Re: 15 Prince Avenue, Peaks Island

Thank you for the opportunity to work on this project. This letter summarizes structural recommendations for your project at 15 Prince Avenue, Peaks Island.

**S1**  
 Proposed  
 Foundation & 1st Flr.  
 Framing Plan

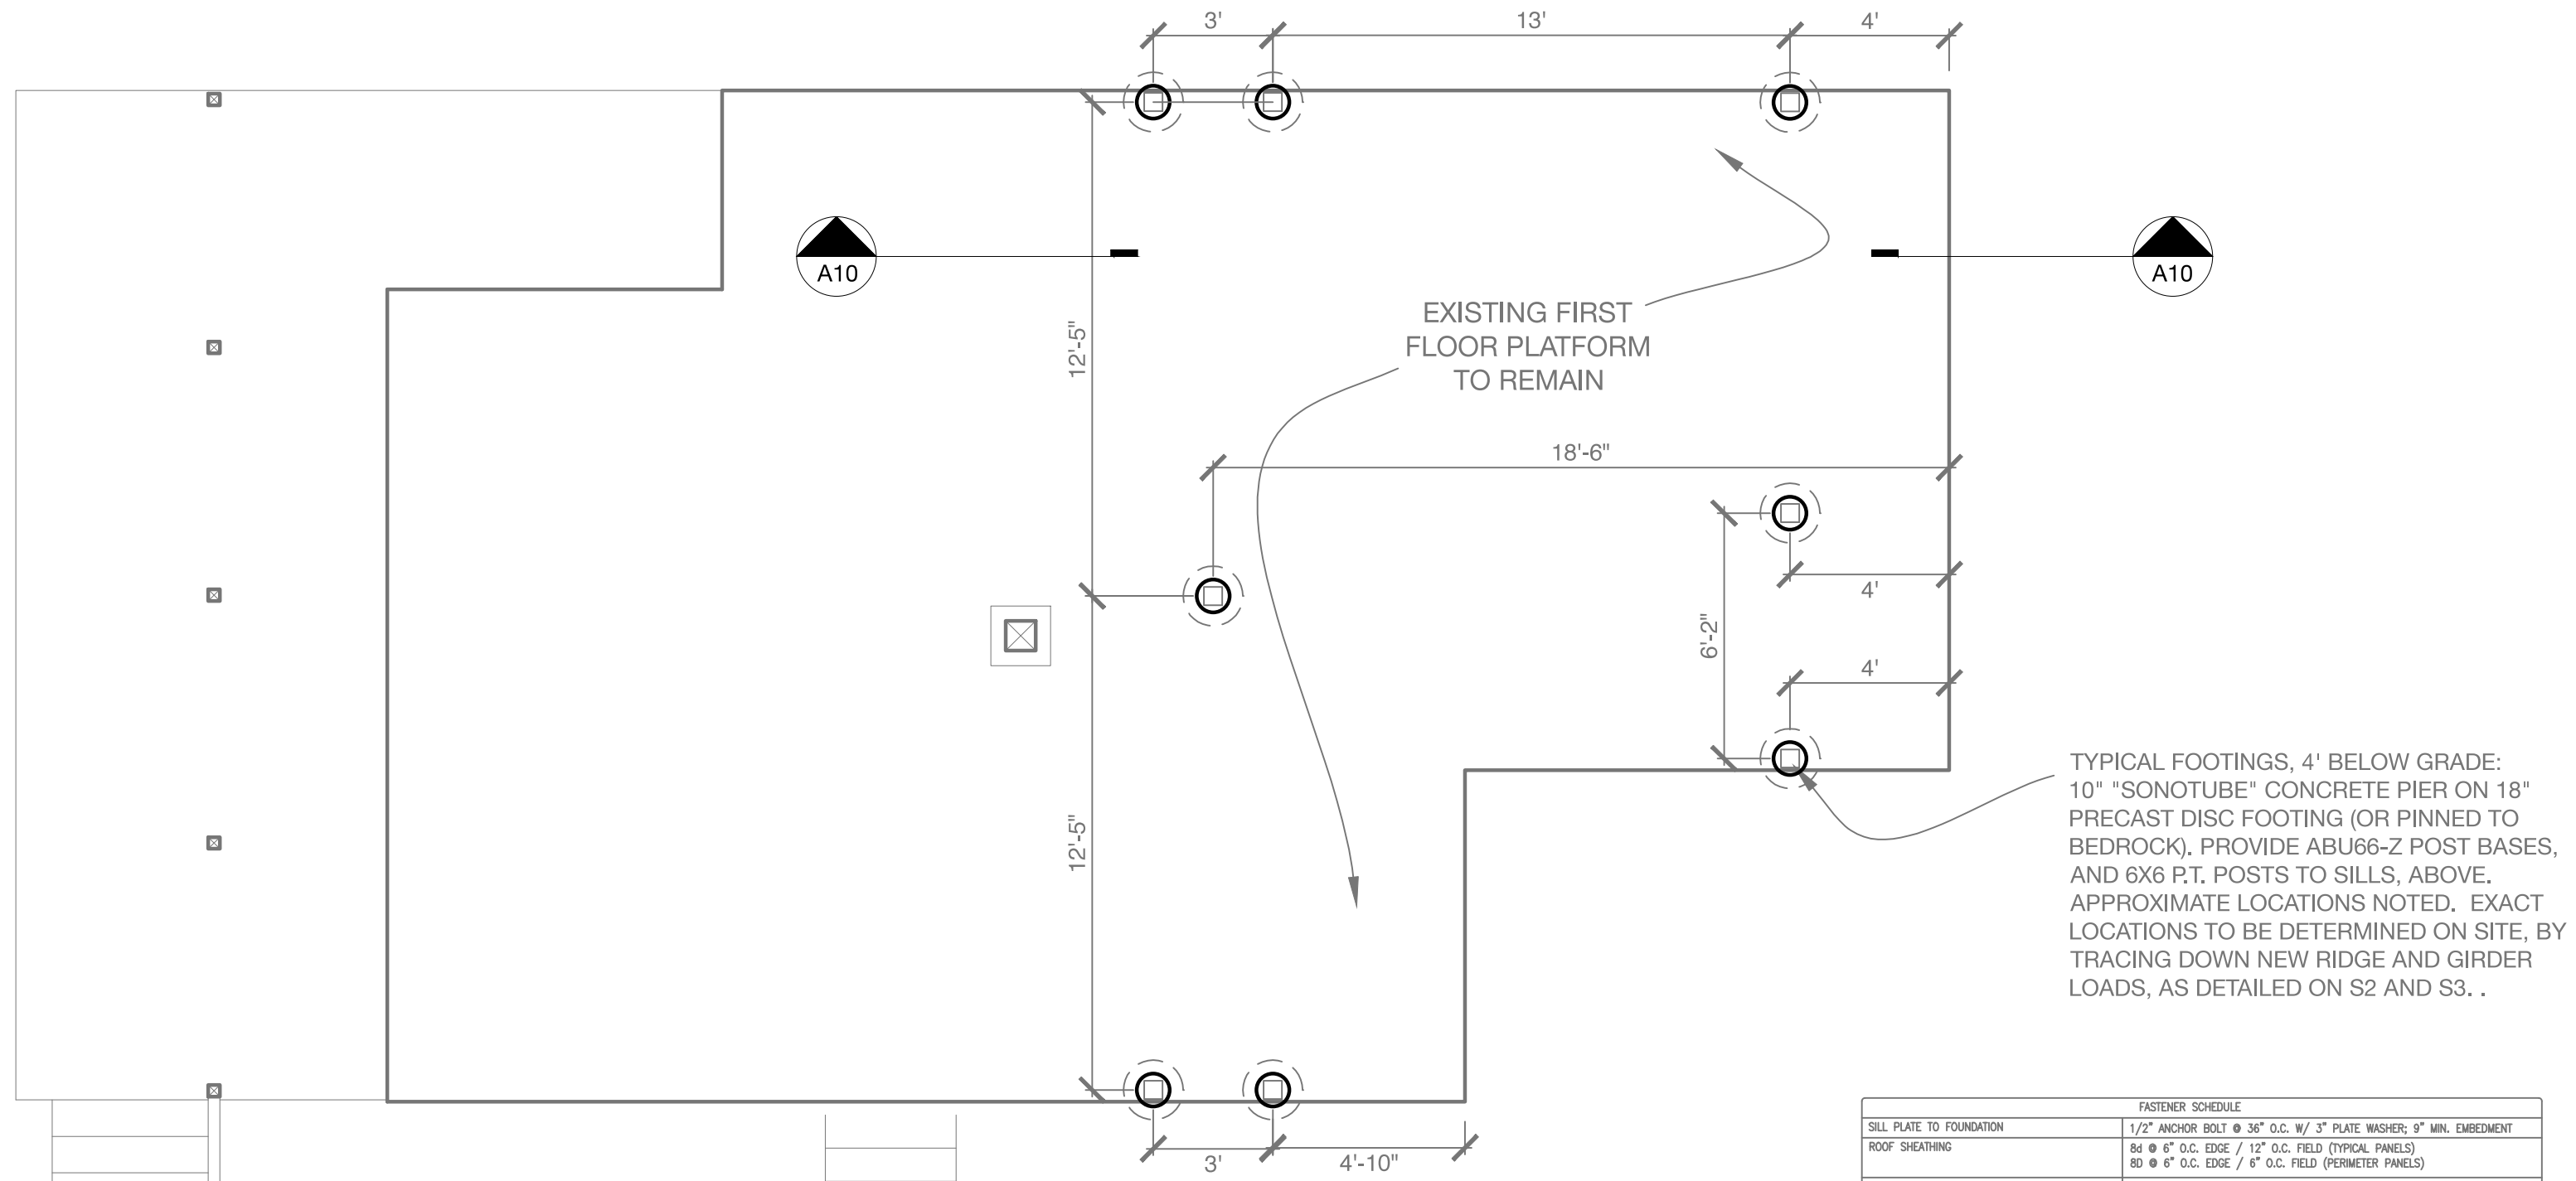
5. New foundation under existing SE wall

- a. Add or replace posts/sonotubes to provide (4) footings total. Each footing to be 9" square on rock (15" square on soil). Piers to be under existing sill beam, max pier spacing 6' o.c. or under splice point in rim, as required. See note (v) for typical post and pier sizes.
- b. Alternate frost wall: 8" continuous strip footing on rock w/ (2) #4 rebar continuous, 12" strip footing on soil. Use 6" or 8" CMU block, solid or grouted solid, to make wall between top of footing and bottom of existing sill beam. Use ladder reinforcement at bed joints between CMU block courses. Shim between top of block and bottom of existing sill beam with plastic heavy-duty load-bearing shims to transfer load to new frost wall.

S2
Proposed 2nd Flr.
& Balcony
Framing Plan

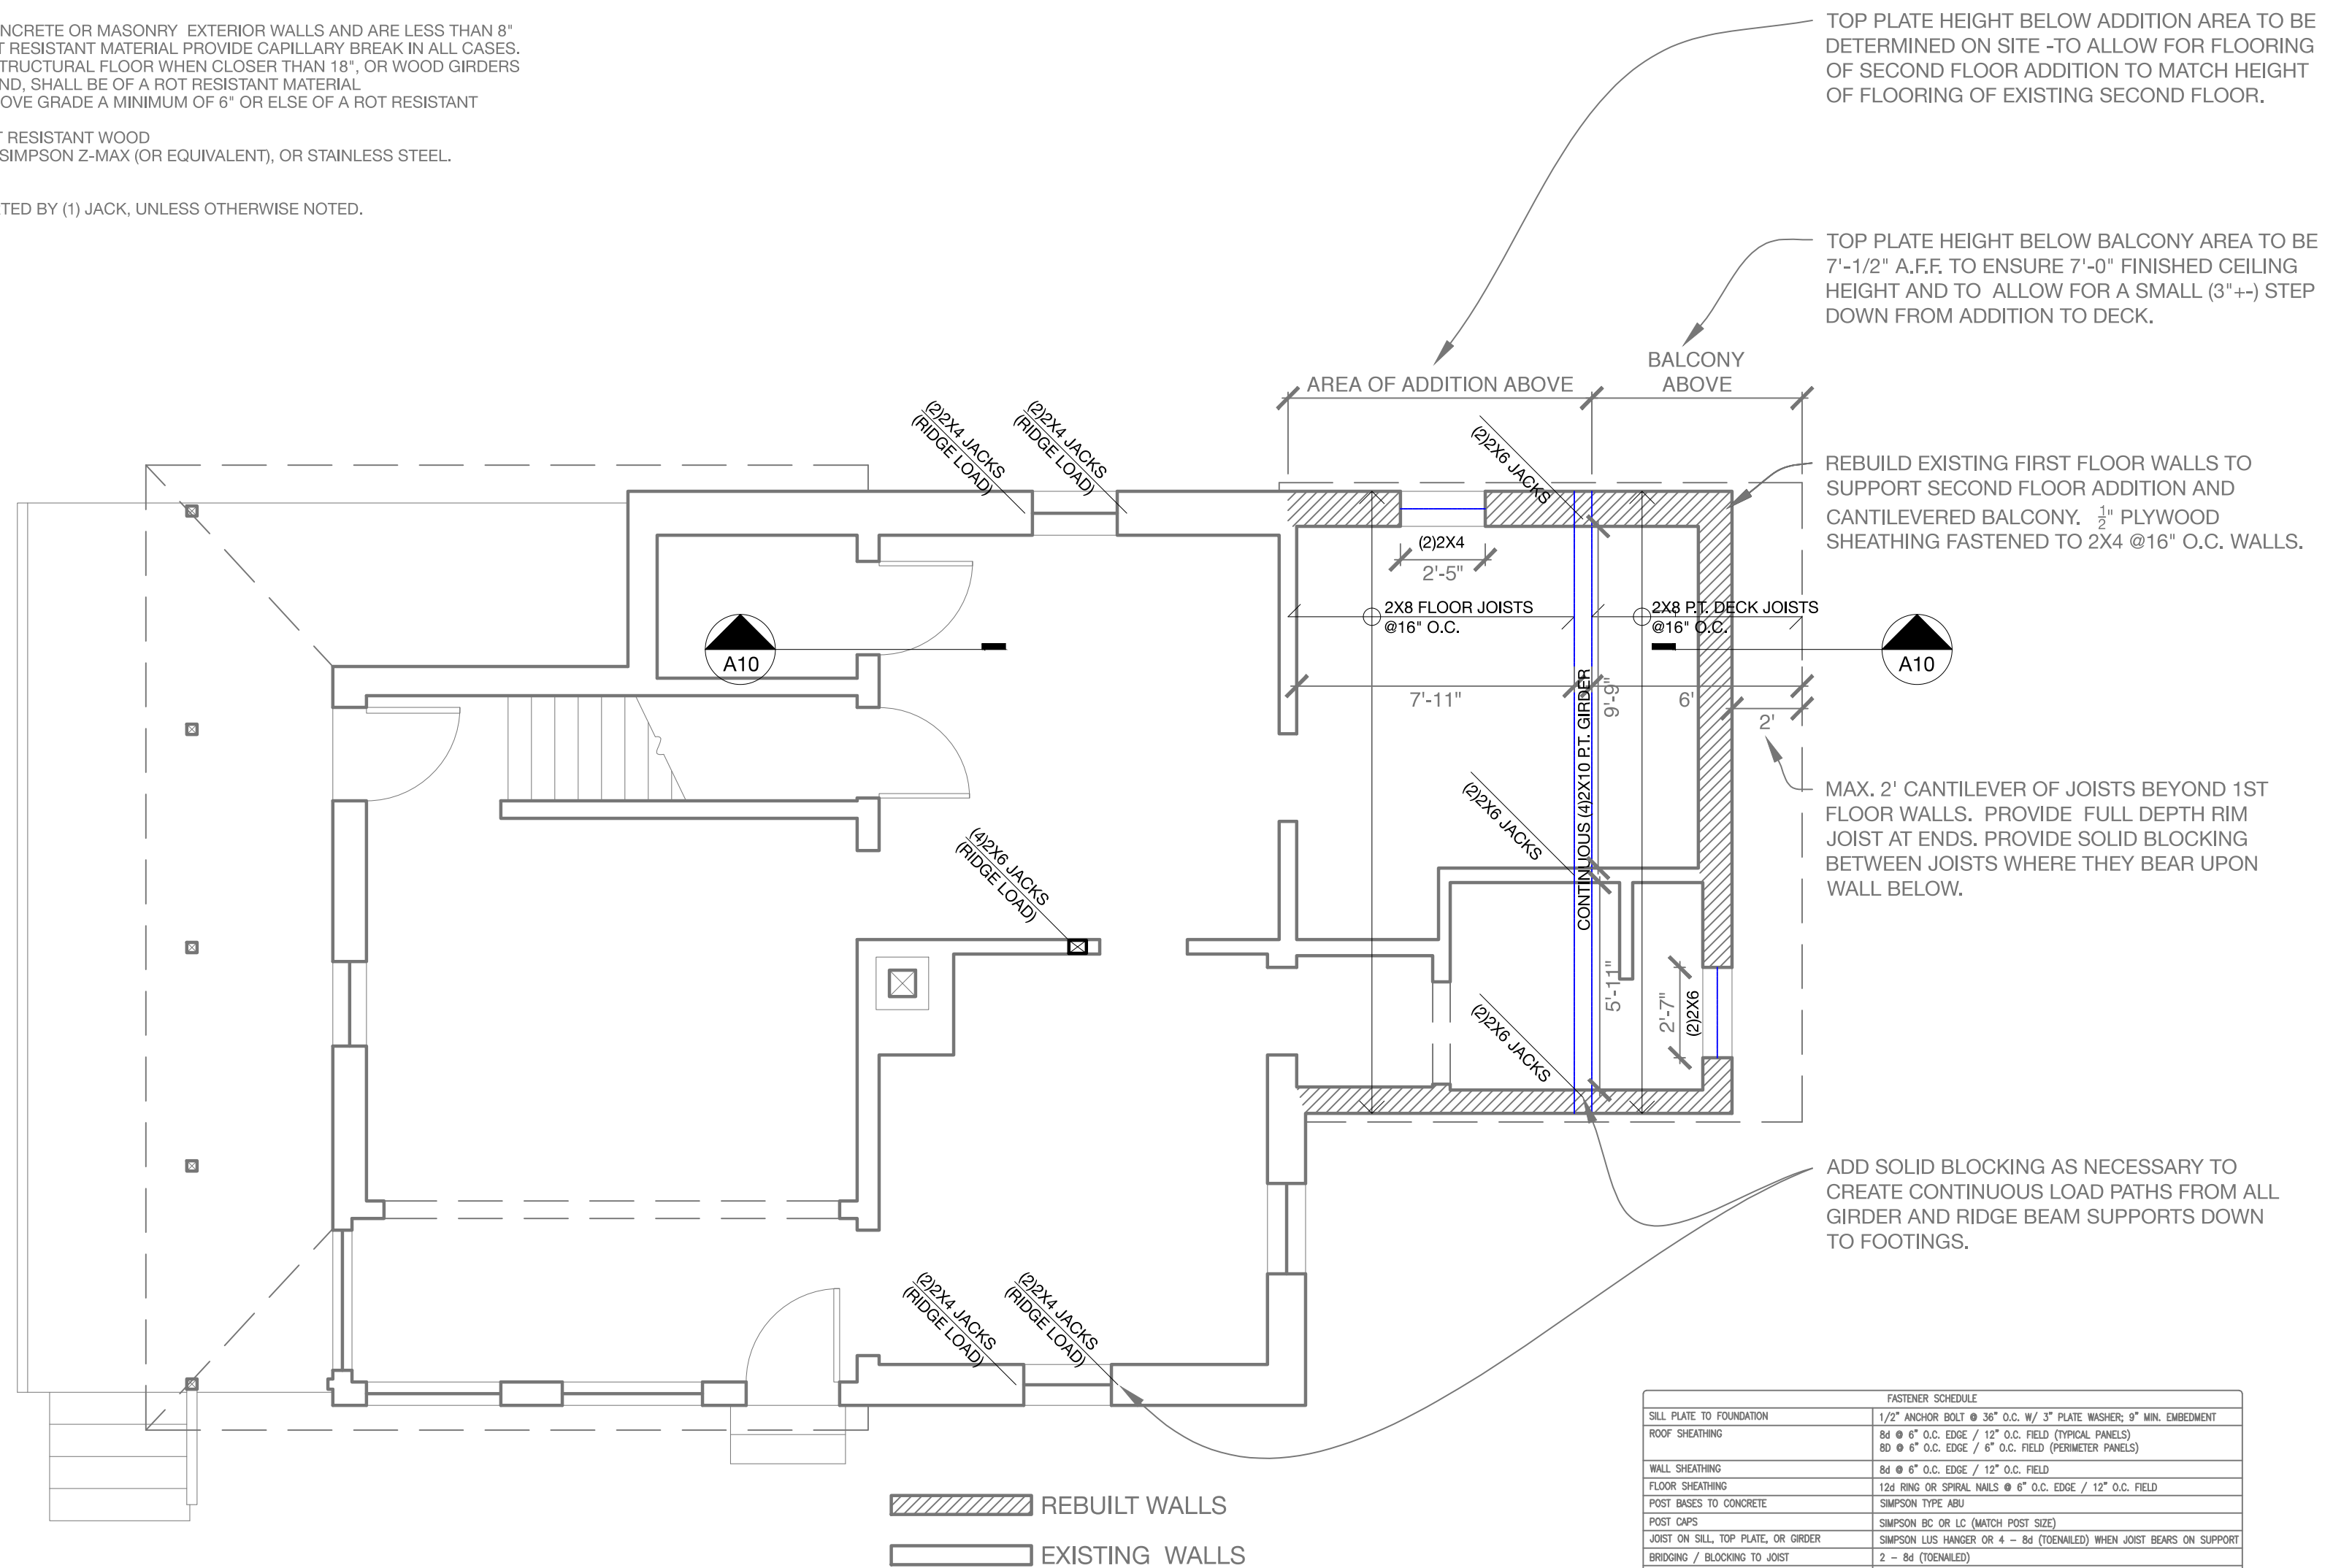
3. Beam in ceiling of first floor

- a. There is a bearing wall under the rafters noted in (2) above that is on a beam in the ceiling of the first floor. This beam needs to be (4) 1.75x11.25 LVLs together with a (4) 2x post at either end. Each post needs to be carried down to the foundation with solid blocking if necessary at the floor/rim.
- b. Each post needs to be on a footing that is 1'-3" square x 8" thick on solid rock. If any of these footings ends up on soil the footing needs to be 2'-0" square x 10" thick. See note (v) for typical post and pier sizes.

4. New porch / balcony joists (see sketch)

- a. 2x8 @ 16
- b. NE end of these joists bears on beam noted in (3) above.
- c. The middle of these joists bears on the existing SE wall of the house. See (5) below for details related to the new foundation required under this wall.
- d. The ends of these joists will project out up to 4'-6" towards the SE with a diagonal strut support back to the existing wall (see detail).

S3
Proposed
Roof
Framing Plan

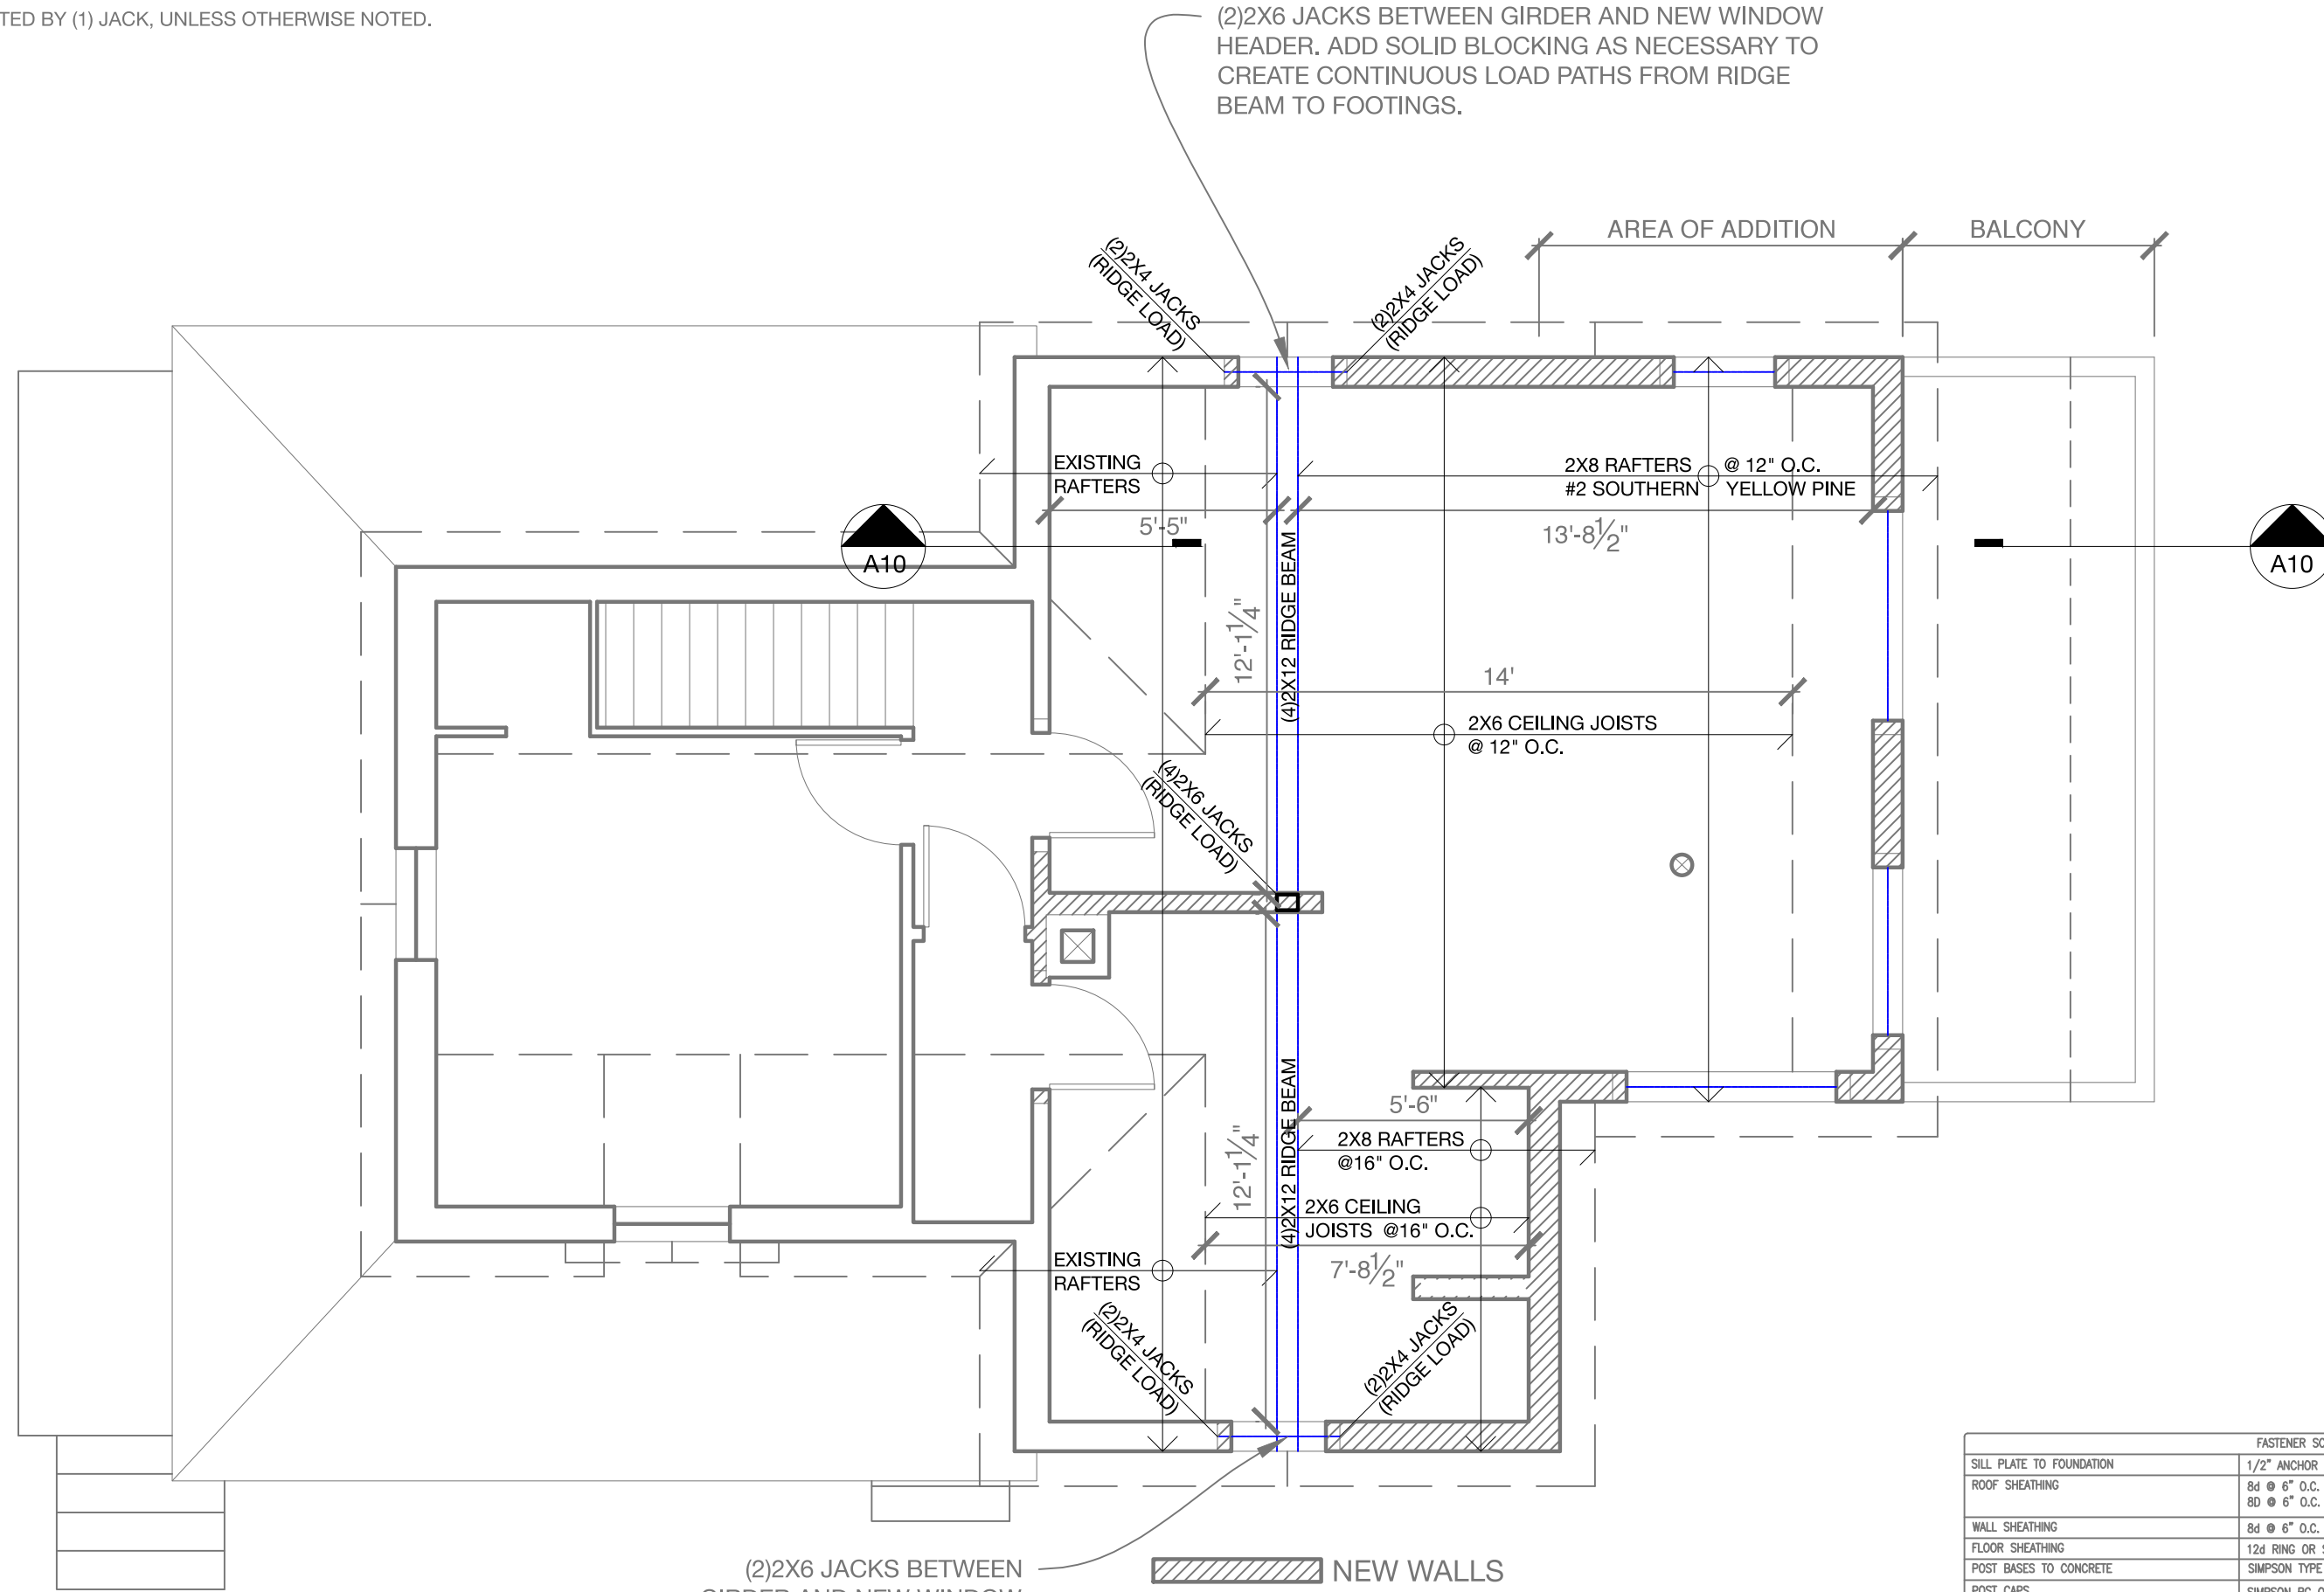
1. Ridge Beam—25' span

- a. (4) 1.75x16 LVLs together.
 - i. Note that this is expected to sag up to 3/4" under snow loads so be aware of that if there are any brittle finishes like sheetrock attached to the ceiling under this beam.
- b. (4) 2x6 post at either end of this ridge.
- c. (3) 2x10 header over window opening with one king stud and two jack studs each side (six total per side). Each of these triple studs needs to be carried down to the foundation with solid blocking if necessary at the floor/rim.
- d. Each post (four total under the ridge) needs to be on a footing that is 1'-0" square x 8" thick on solid rock. If any of these footings ends up on soil the footing needs to be 1'-9" square x 10" thick. See note (v) below for typical post and pier sizes.

2. New rafters on the SE side, towards the shed—16' span

- a. 2x8 @ 10" or 2x10 @ 16"
- b. You can expect about 1/2" sag in these rafters under heavy snow loads.
- c. Provide solid blocking between rafter ends and Simpson H1 ties at every other rafter.
